From: Amanda Scholes on behalf of Planning.Responses
Sent: 29 November 2017 08:52
To: Planning Scanning
Subject: FW: Ref Planning Application FP/268/17/PL

From: Roger Spencer
Sent: 28 November 2017 15:00

PROJECT Gull Point Suites - On the Beach
TITLE Typical Sections
SCALE 1 : 100
DATE 20/09/17
DRG NO IBA/480/09
REVISIONS

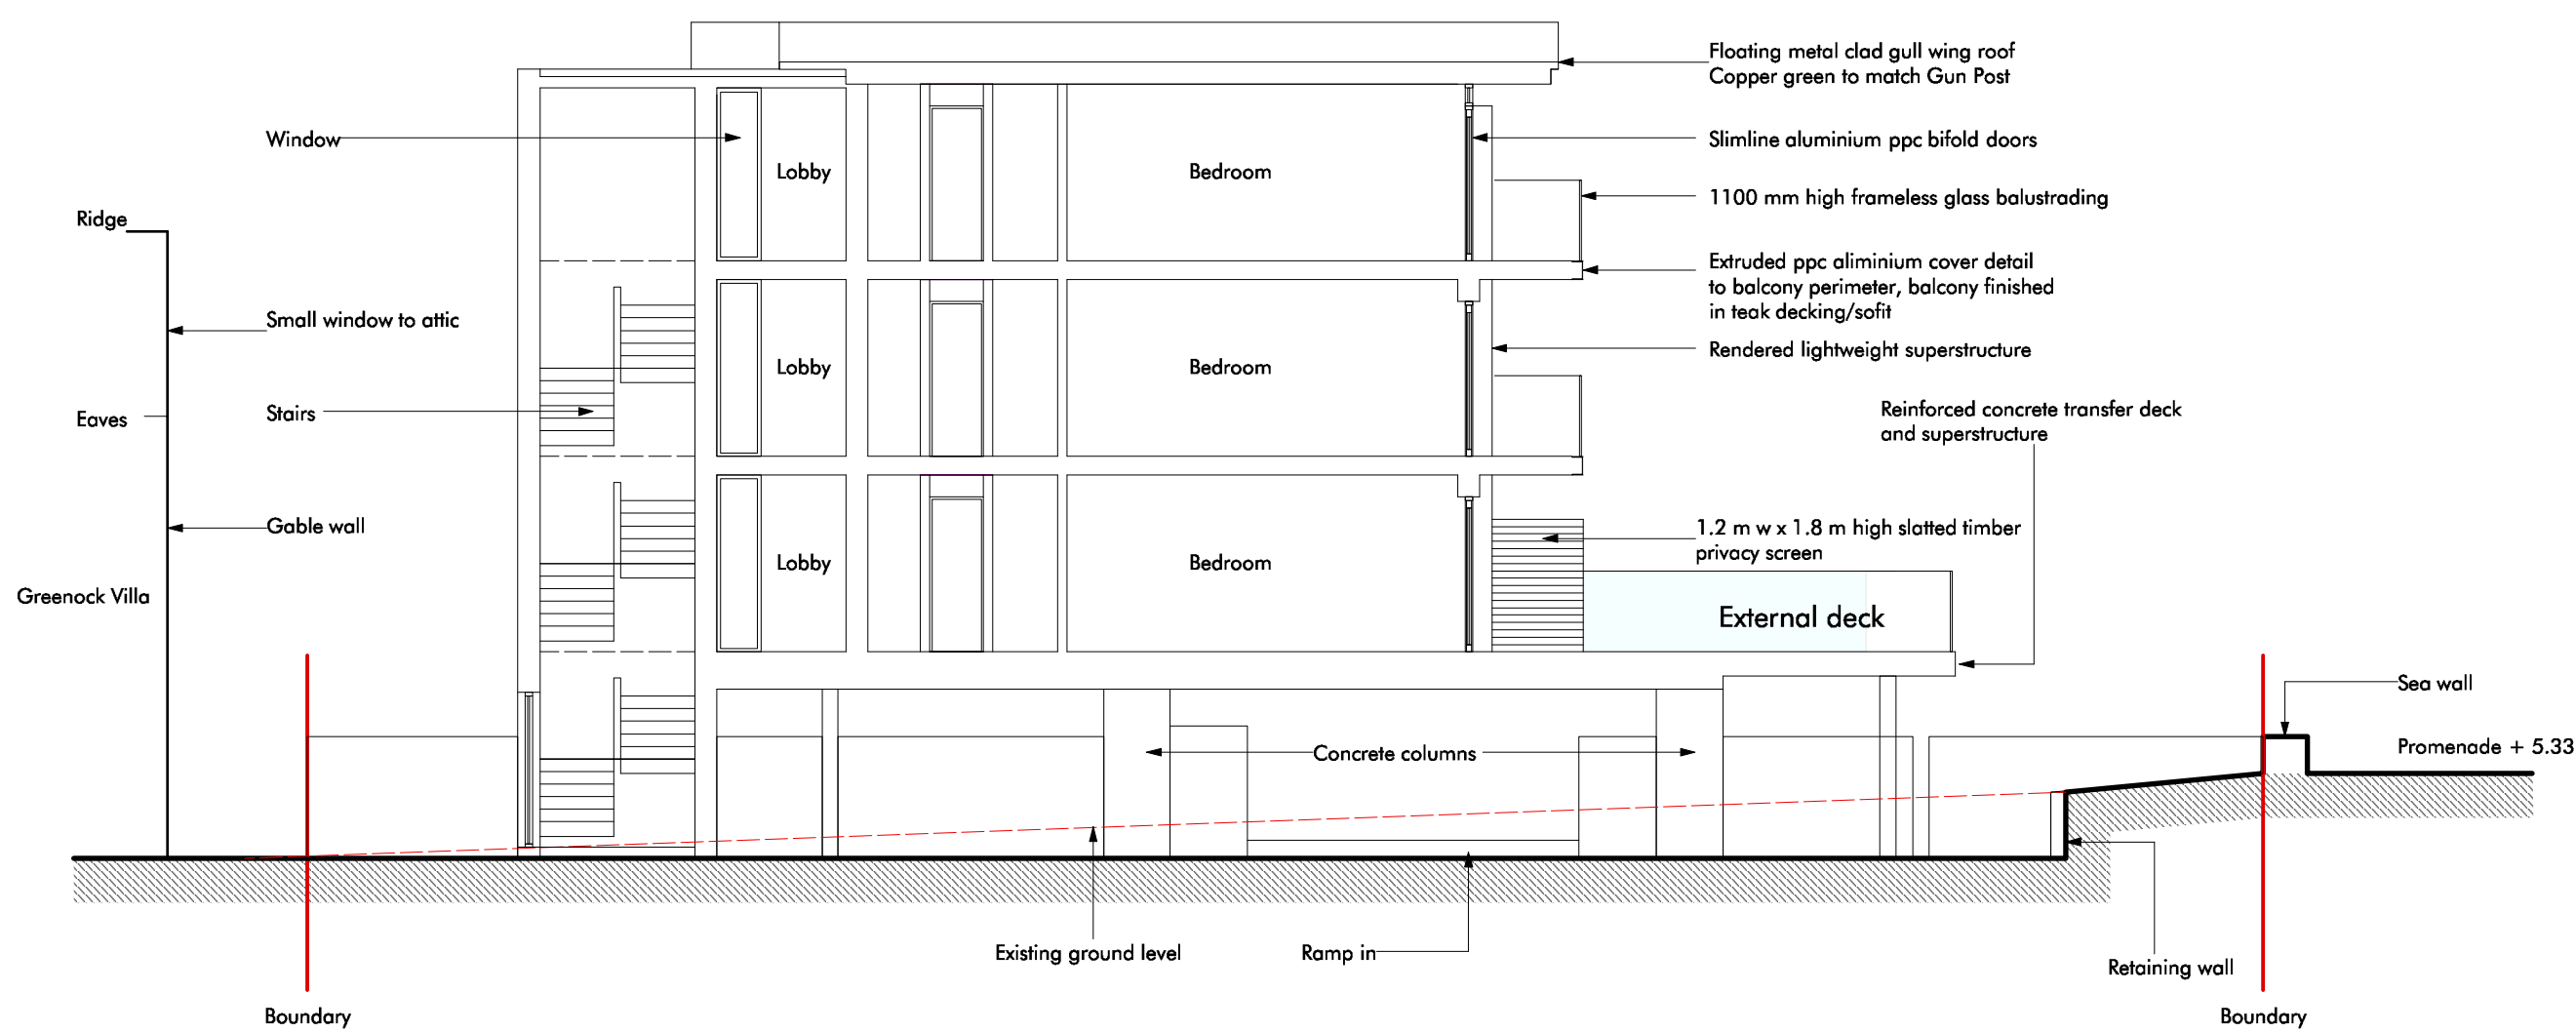
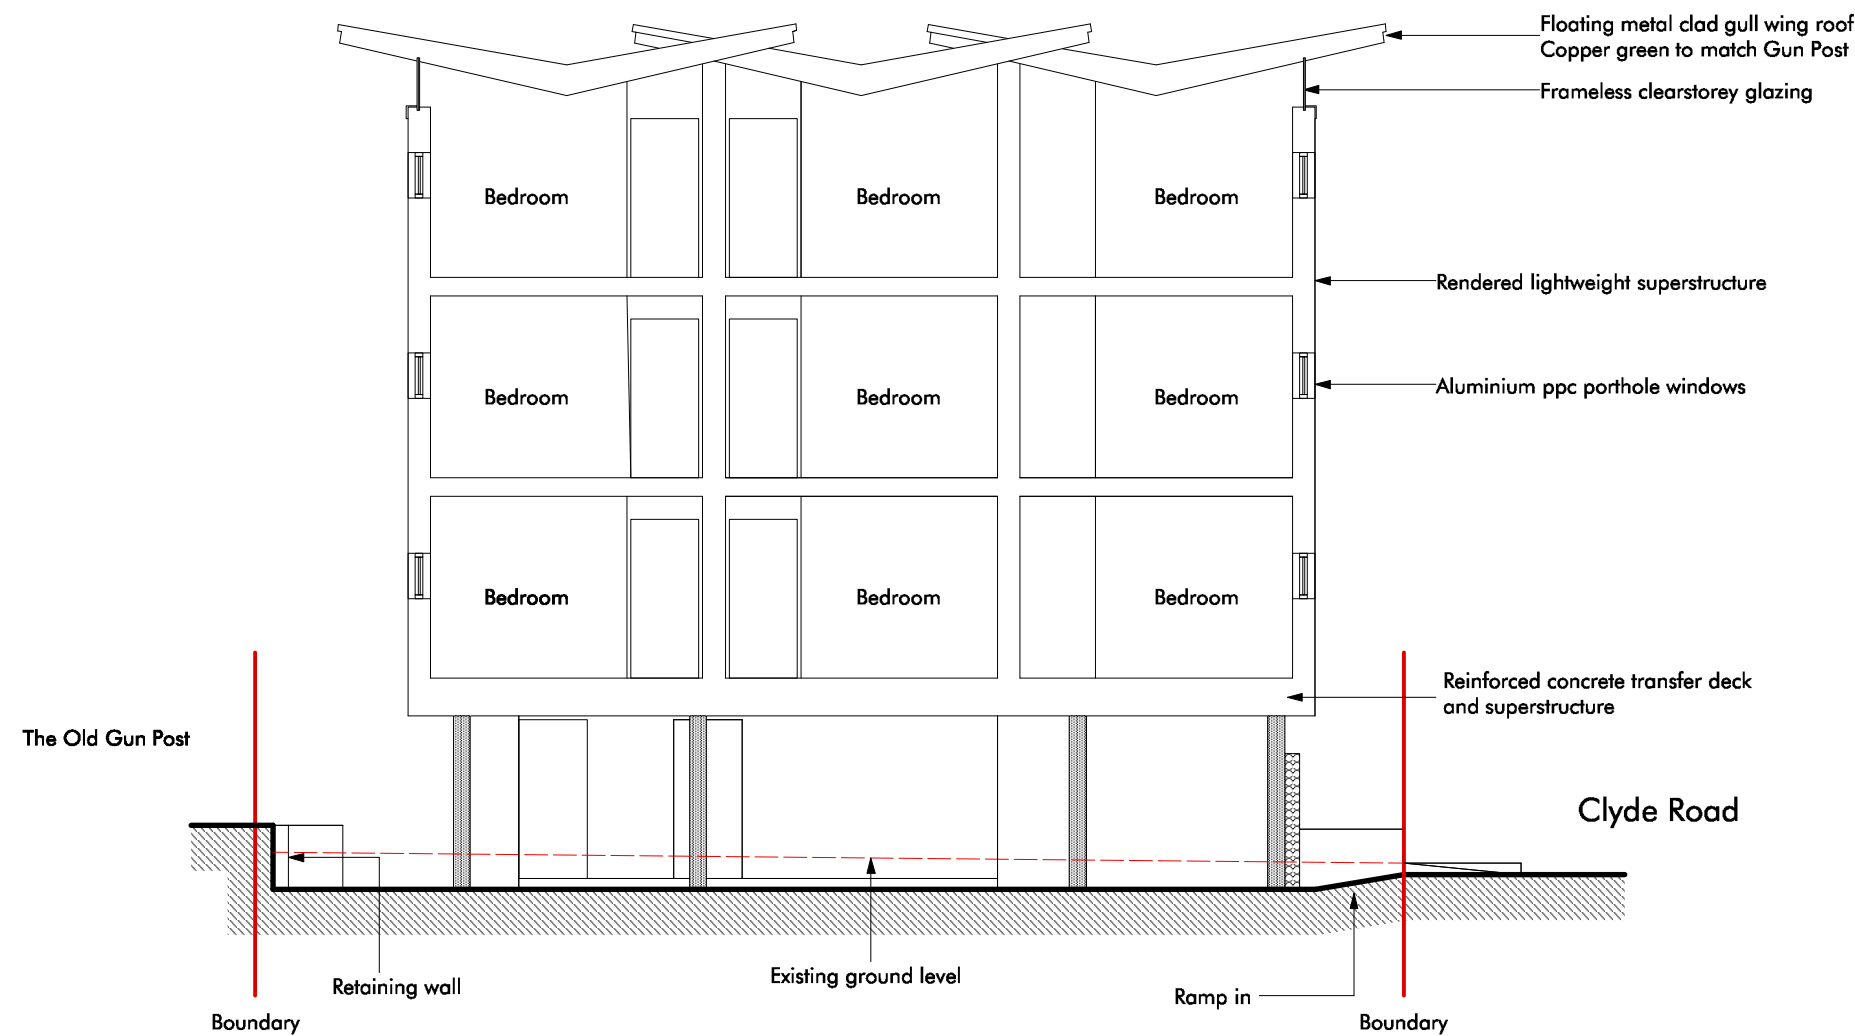
Whilst these references allude to the proposed low timber wall, they do not give sufficient importance, in my opinion, to the job of keeping the sea out. I would have expected to have seen the wall shown in both of your Elevations drawings as well as the Sections drawing (unless that is it is concealed by the red boundary line!).

However, can I please draw your attention to our landscaping drawing and landscape design strategy, both these documents make reference to a hardwood timber wall behind the existing sea defence wall, within our landscaped area along the eastern boundary, to act as a secondary line of defence. This timber wall will be slightly set back from the existing sea defence wall at the back of the promenade and will be some 500 mm higher than the existing sea defence wall.

PROJECT Gull Point Suites - On the Beach
TITLE Site Plan
SCALE 1 : 100
DATE 20/09/17
DRG NO IBA/480/02
REVISIONS

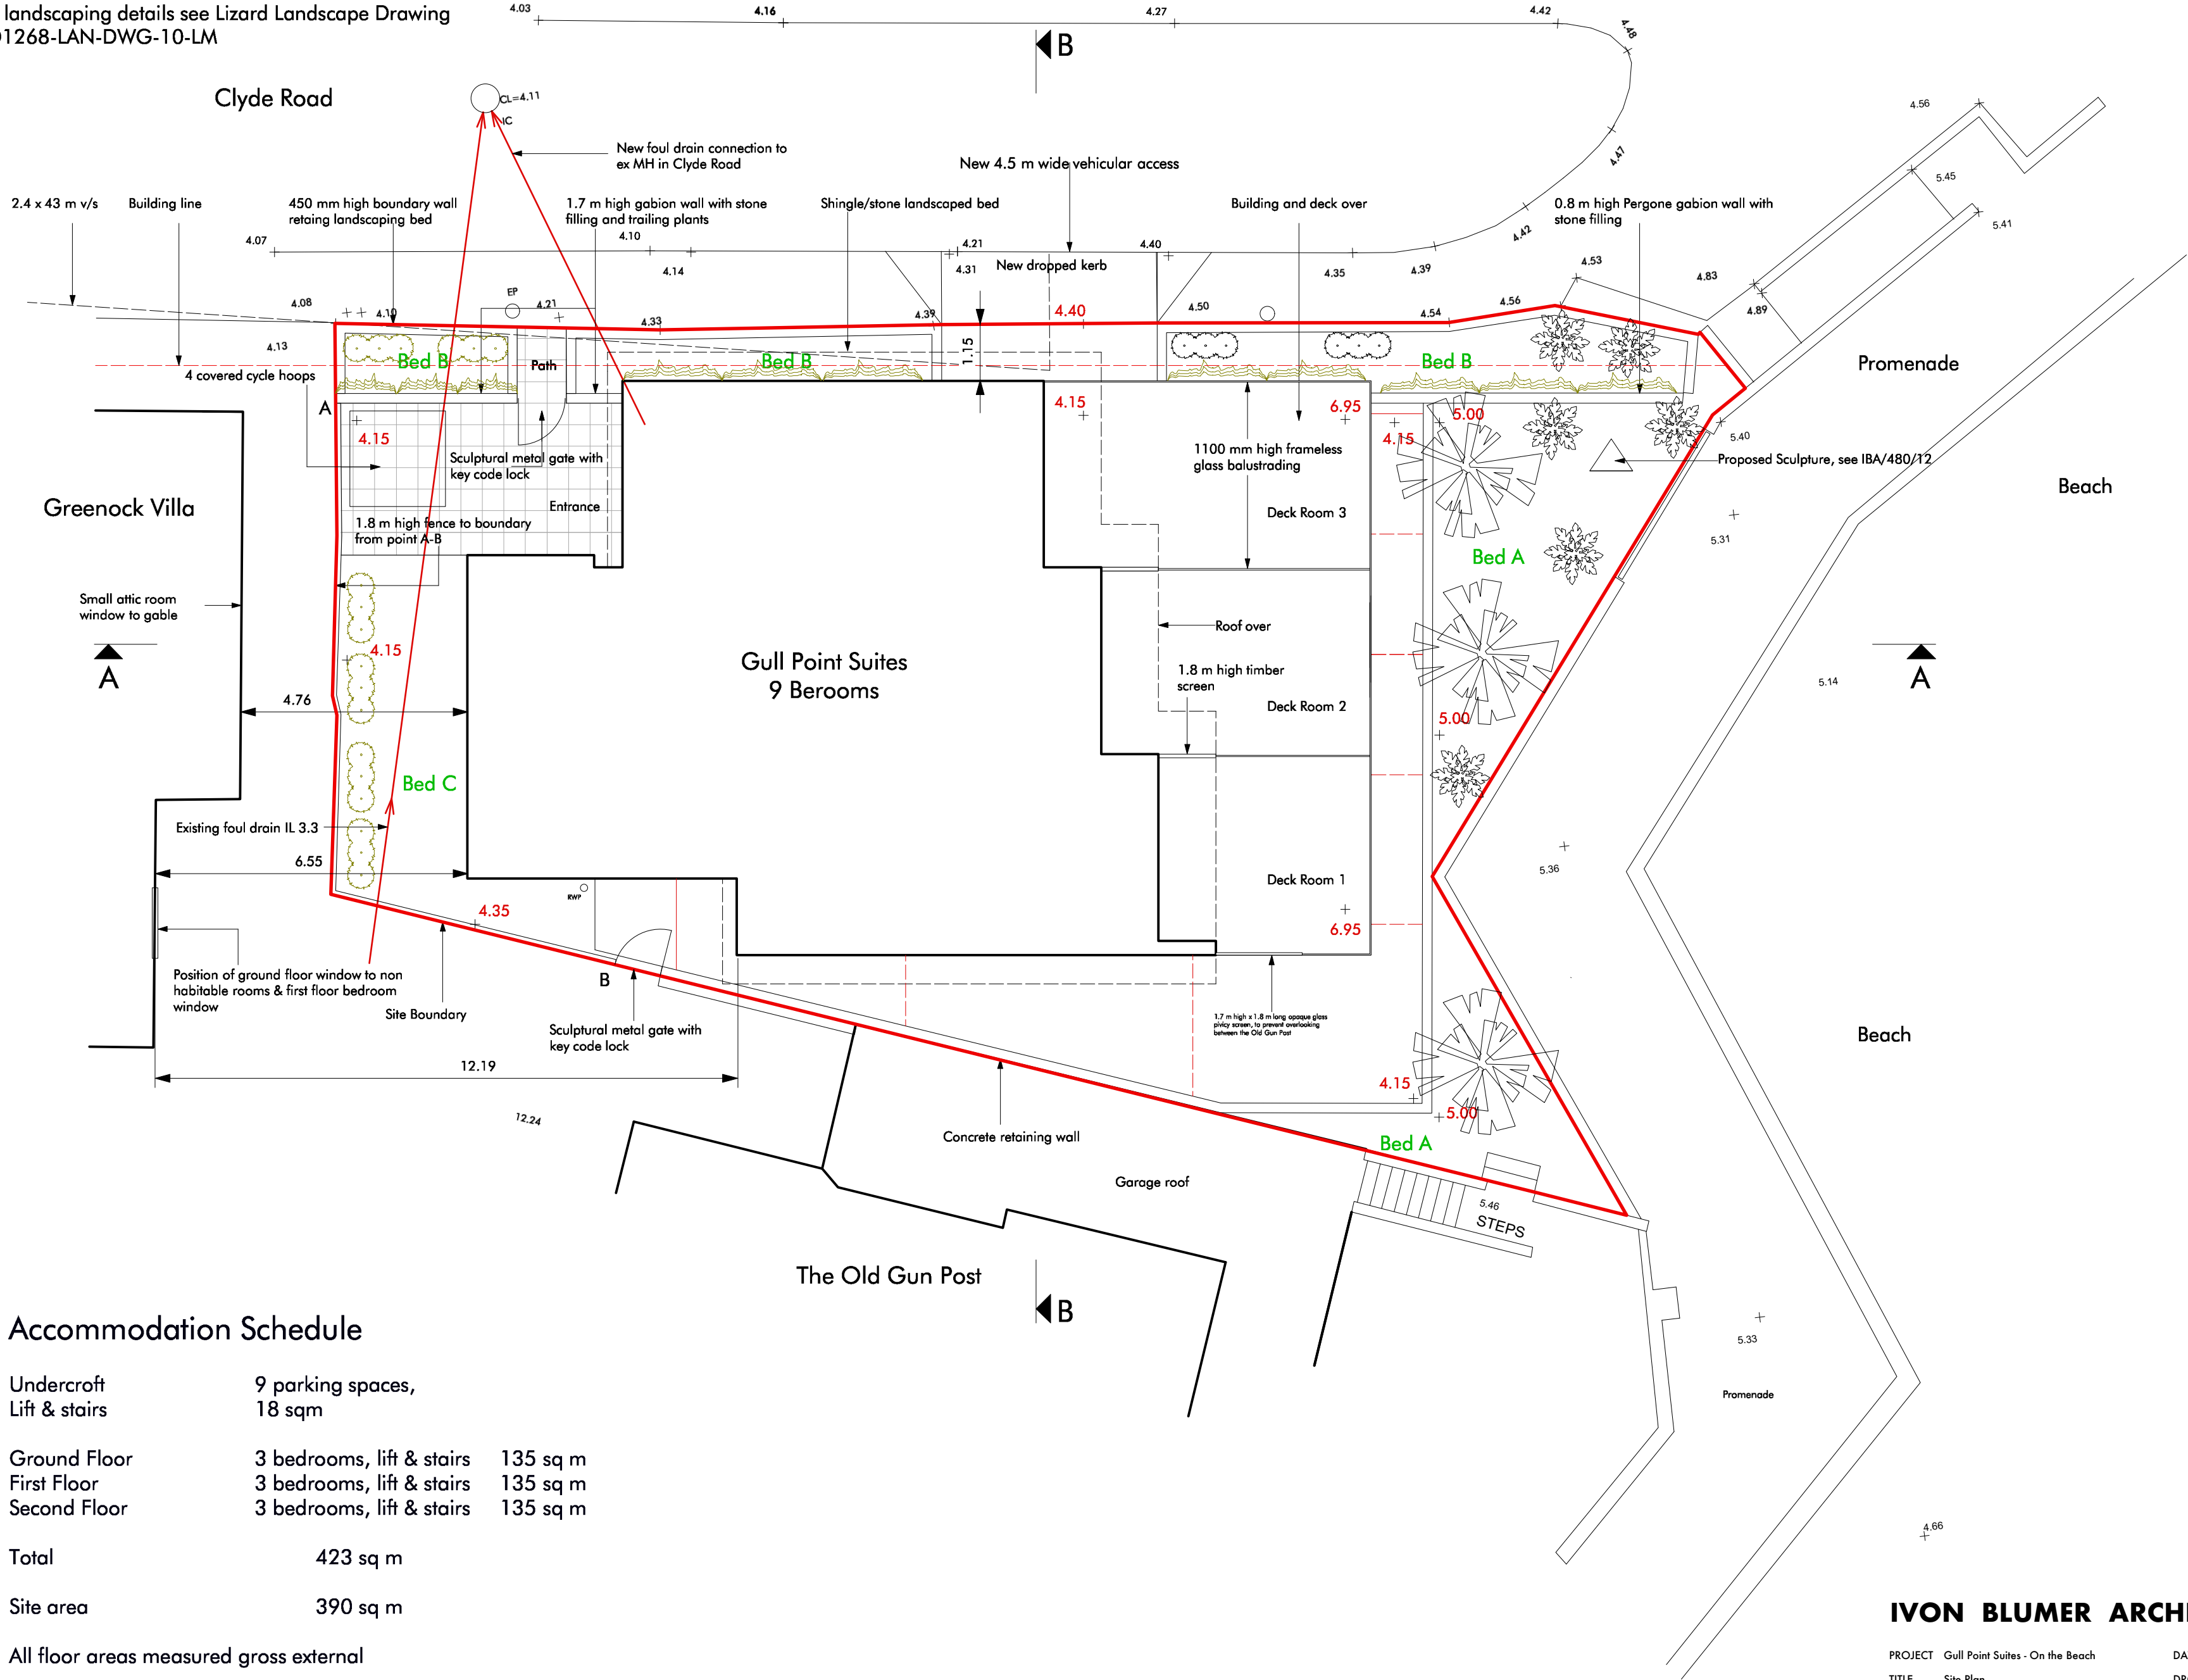
Thank you for bringing my attention to the note on your Landscape Masterplan drawing and the reference in 4.7 and bp2 of 4.11 of the strategy.

I have attached a screen shot of the note on the landscaping drawing for your information.
